From: Ian Brewster
Sent: 22 February 2012 11:39
To: Eve Hearsey
Subject: RE: FORMAL CONSULTATION - FG/16/12/ - COUNTRY FAYRE (ASDA), LITTLEHAMPTON ROAD, FERRING

I understand that approval for the ASDA development has been granted. Regarding the planting of trees within the site my comments are based purely from the proposed site plan (scale 1:500), as follows;

Subject: FORMAL CONSULTATION - FG/16/12/ - COUNTRY FAYRE (ASDA), LITTLEHAMPTON ROAD, FERRING

Proposed Site Plan

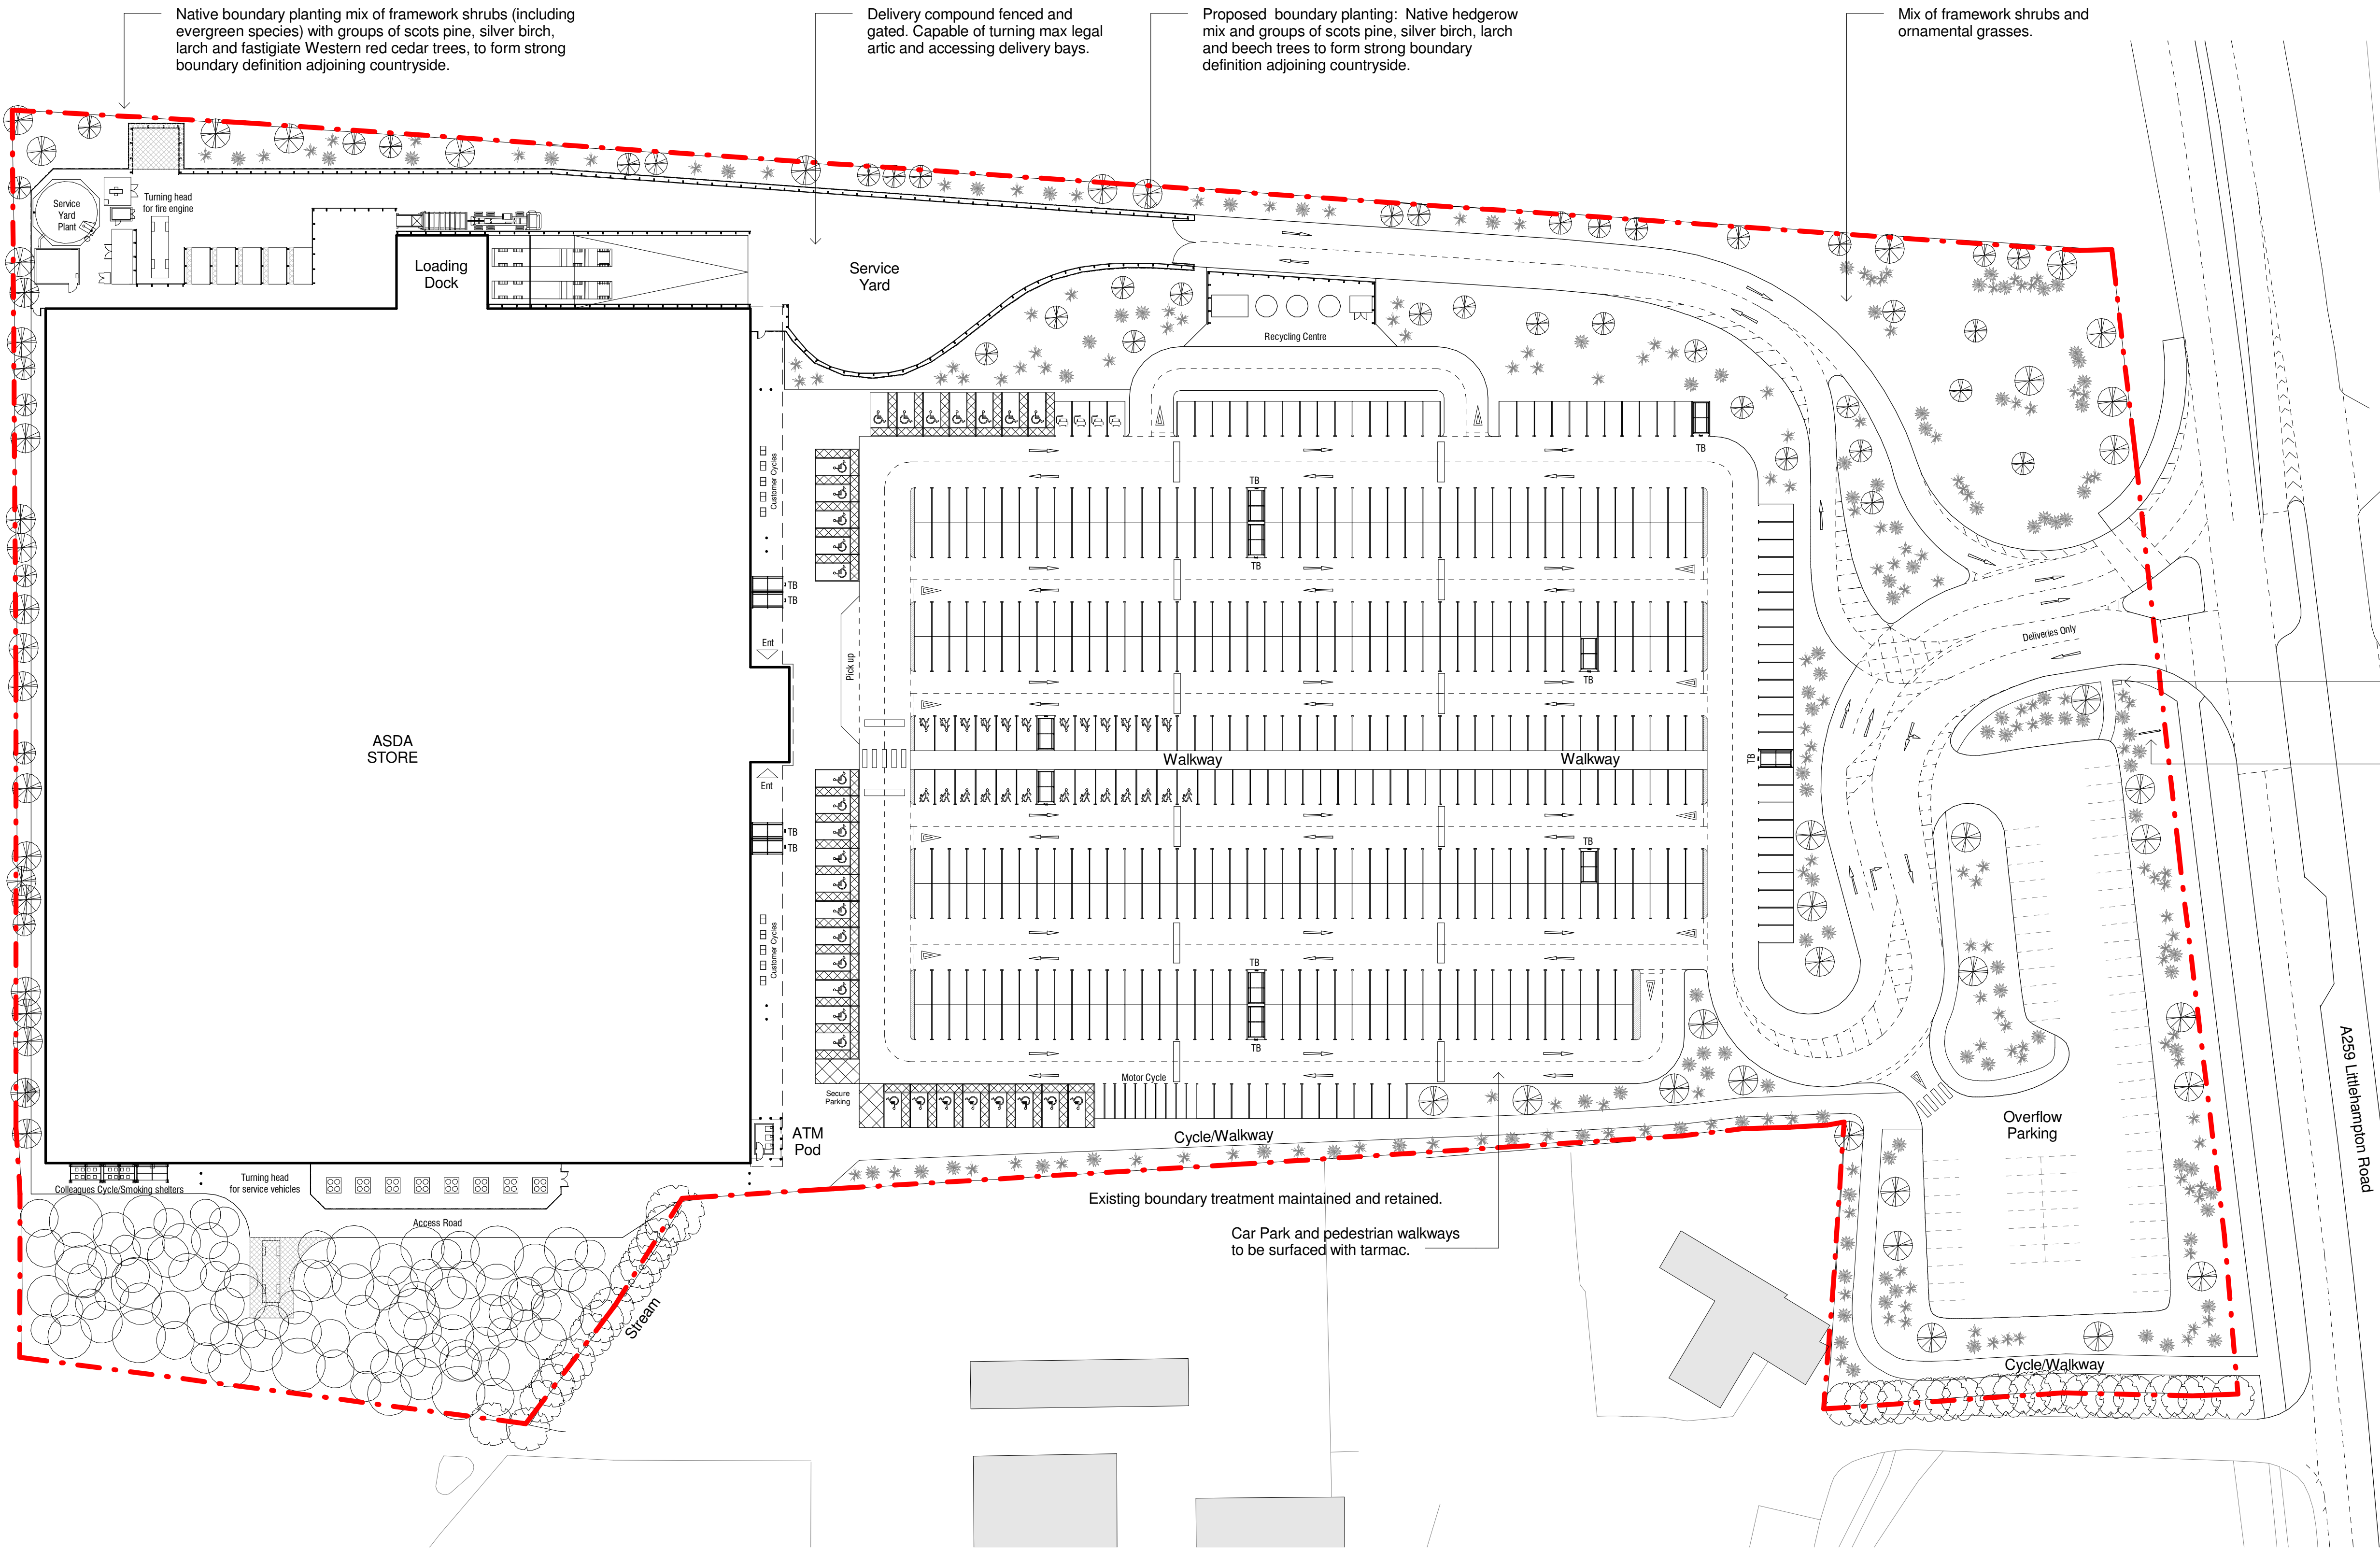
The width of the western boundary measures 3.5m. The proposed planting of Scots Pine, Silver Birch and Beech trees will mature and their branches will overhang the access driveway to the loading dock/Service yard. Vehicles using this route will be high sided HGV. Tree planting would need to set at a sufficient distance to reduce the need for drastic pruning work, eliminating the creation of an un-balanced line of trees and increase their life expectancy. It is therefore recommended that the verge is widened to accommodate broad spreading trees or that they are planted at a distance of 0.5m from the boundary to allow at least 3m lateral branch growth without the need for pruning hard back from the driveway. Please note that the planting of Larch is not recommended due to its recent association with the fungal disease Phytophthora. I would suggest provenant and locally sourced English Oak as a possible replacement for Larch.

The overflow car park to the north east is opposite to the planting area (approximately 30x40m) north west and from a visual perspective as viewed from the A259 Littlehampton Road appears unbalanced. It would be appropriate to provide a similar planting scheme/provision for space by halving the overflow car park and supplement the mix of framework shrubs and grasses with trees, suggesting tall, cleared stemmed Scots Pine trees in groups of 3. This would effectively soften and enhance the entrance, adding a natural and prominent landscape feature that would become visible from the highway.
